The Planning Inspectorate

A46 Newark Bypass – Development Consent Order Application

A46 from Farndon Roundabout to Winthorpe Roundabout, near Newark-On-Trent

Deadline 6 (25 February 2025)

Figure 10: Slough Dyke realignment – extract from AS-007 (General Arrangement Plans) Sheet 25005

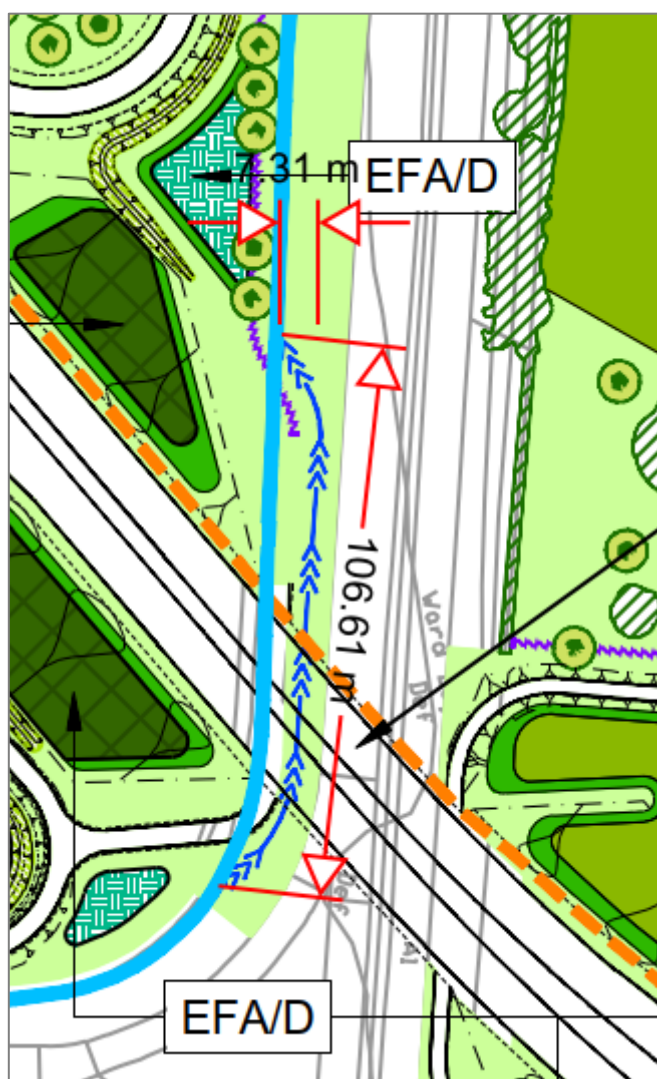
We are satisfied with the draft plans as presented in Appendix A of REP5-063 insofar as it relates to flood risk. However, we raised geomorphological concerns directly with the Applicant in relation to the proposed use of reno mattresses.

The use of reno mattresses and gabion-like structures is not advised for use in watercourses. There is a tendency for the wire cage to fail, which can lead to quite rapid undercutting and instability as material falls from the cage, they do not offer much in the way of habitat benefit, and they can often cause loose and sharp metal to become exposed in the waterway. Our preference is for the use of appropriately sized rip-rap as bank protection.

As it stands, it is unlikely that the Applicant would be granted a flood risk activity permit (FRAP) based on the current plans. However, we are satisfied that the detailed design can be addressed as part of the required FRAP for these works, and the Applicant has confirmed that the plans included in REP5-063 are draft, which will be reflected in the updated Statement of Common Ground to be submitted at Deadline 6.

#### 3.1 Cree's Lane embankment

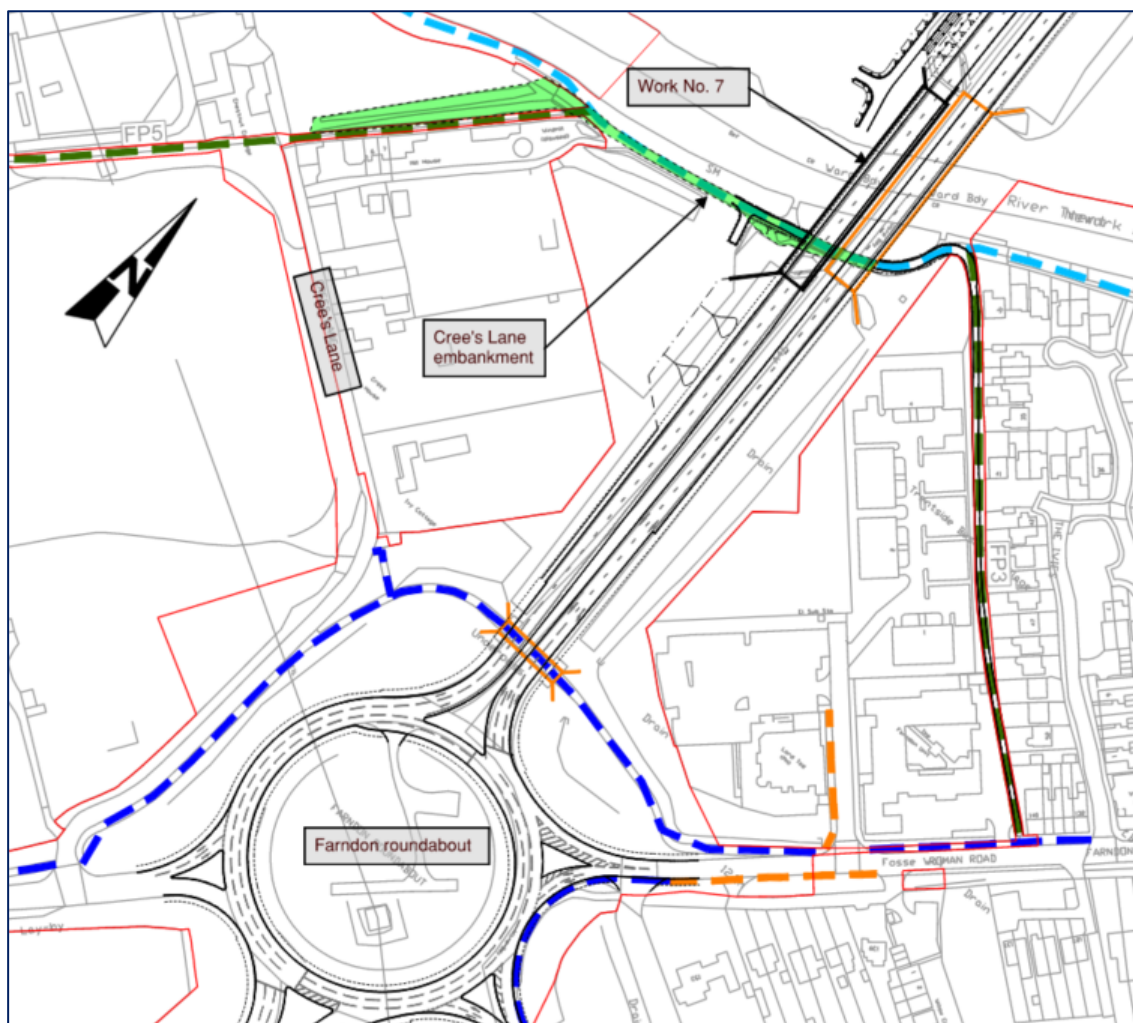
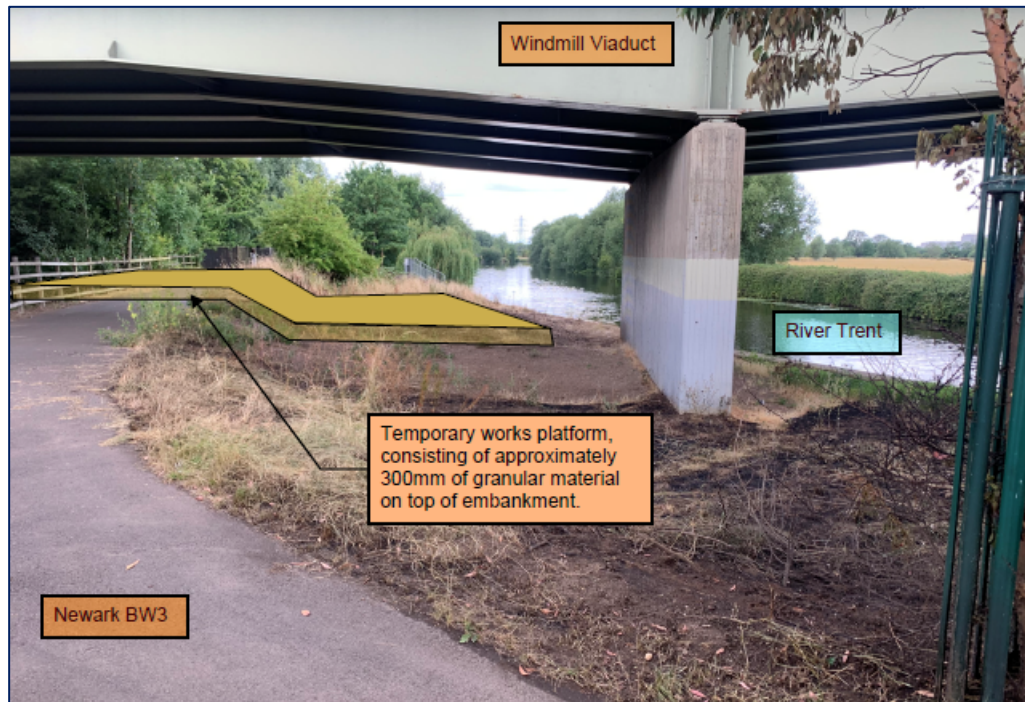
We are satisfied with the information provided in relation to the Scheme's interaction with these flood defences. This point is therefore resolved.

### 3.2 Newark Roundabout embankment

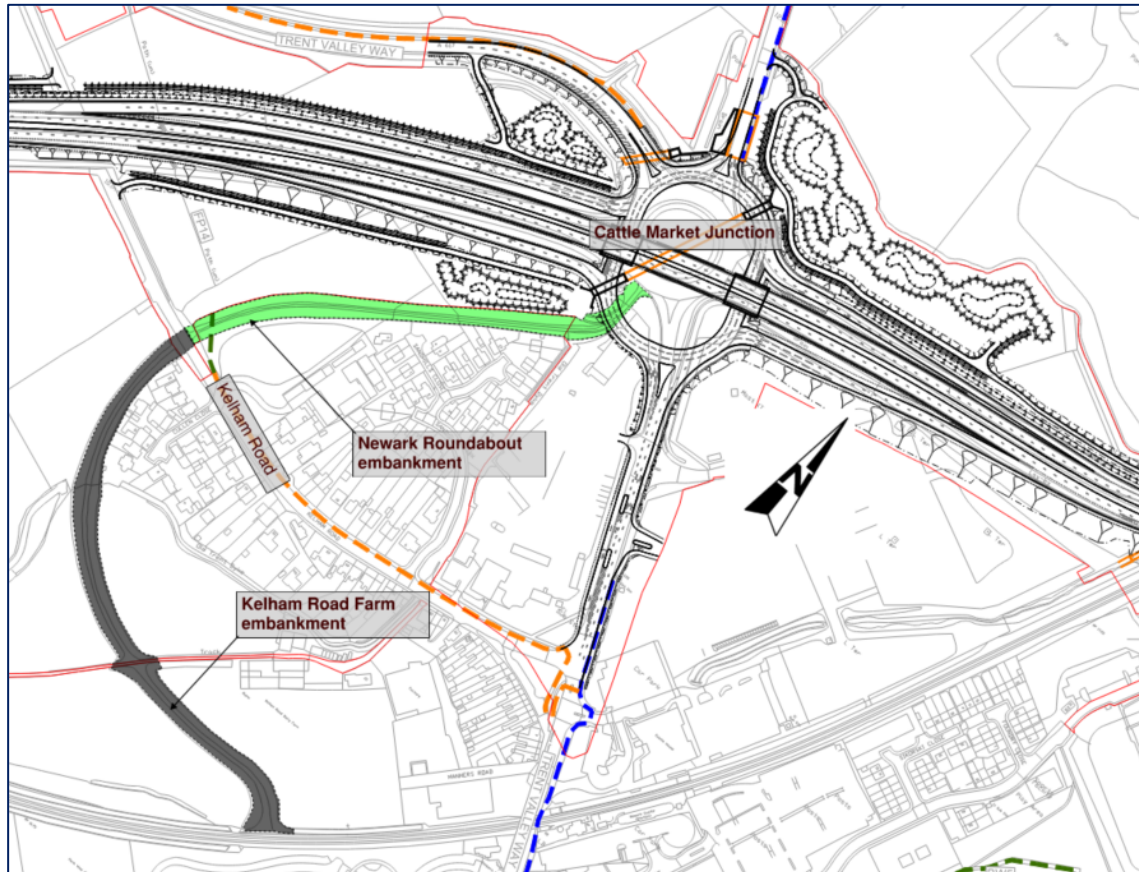
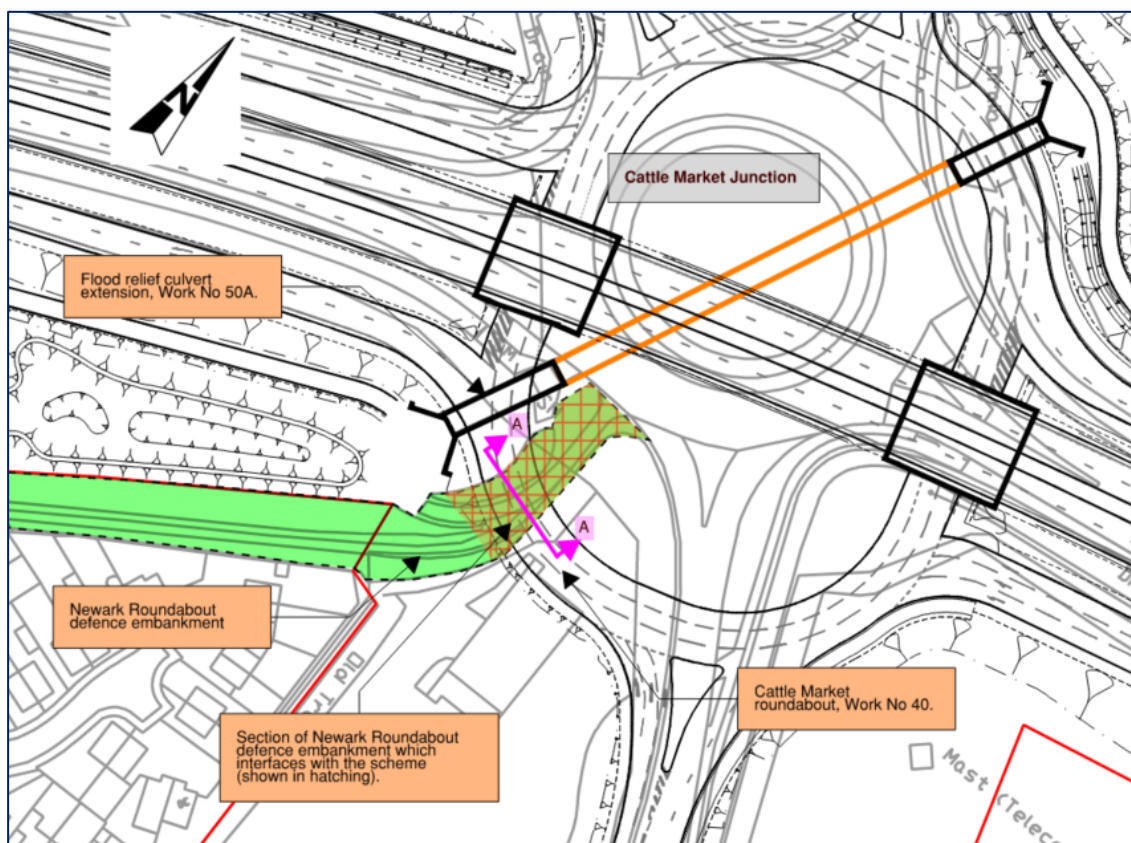
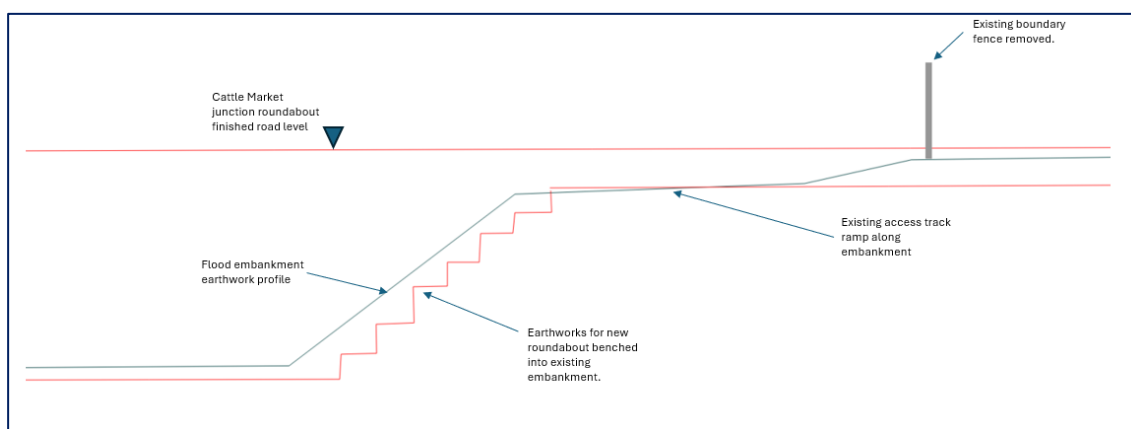
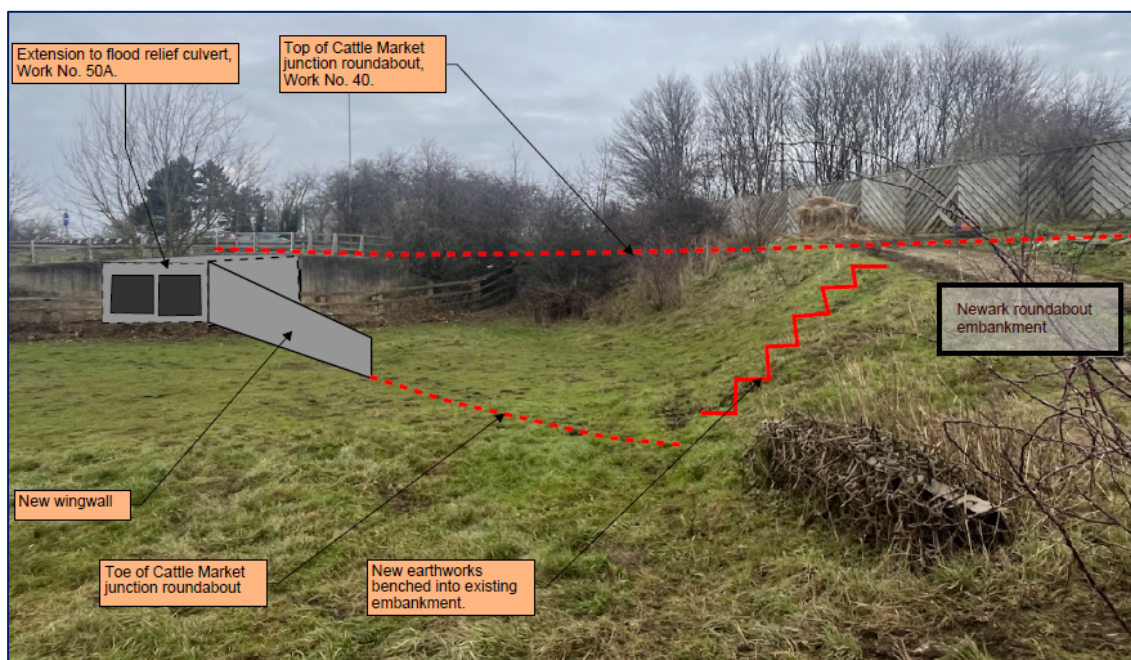
Based on the information submitted in REP5-063, insufficient detail has been presented to satisfy our concerns regarding the Scheme's interaction with these flood defences. We are working to provide the Applicant with further details on what we require to resolve this point. As such, issue EAFR-008 (Interaction with Environment Agency flood defences), as raised in our Relevant Representations [RR-020] remains outstanding based on this point.
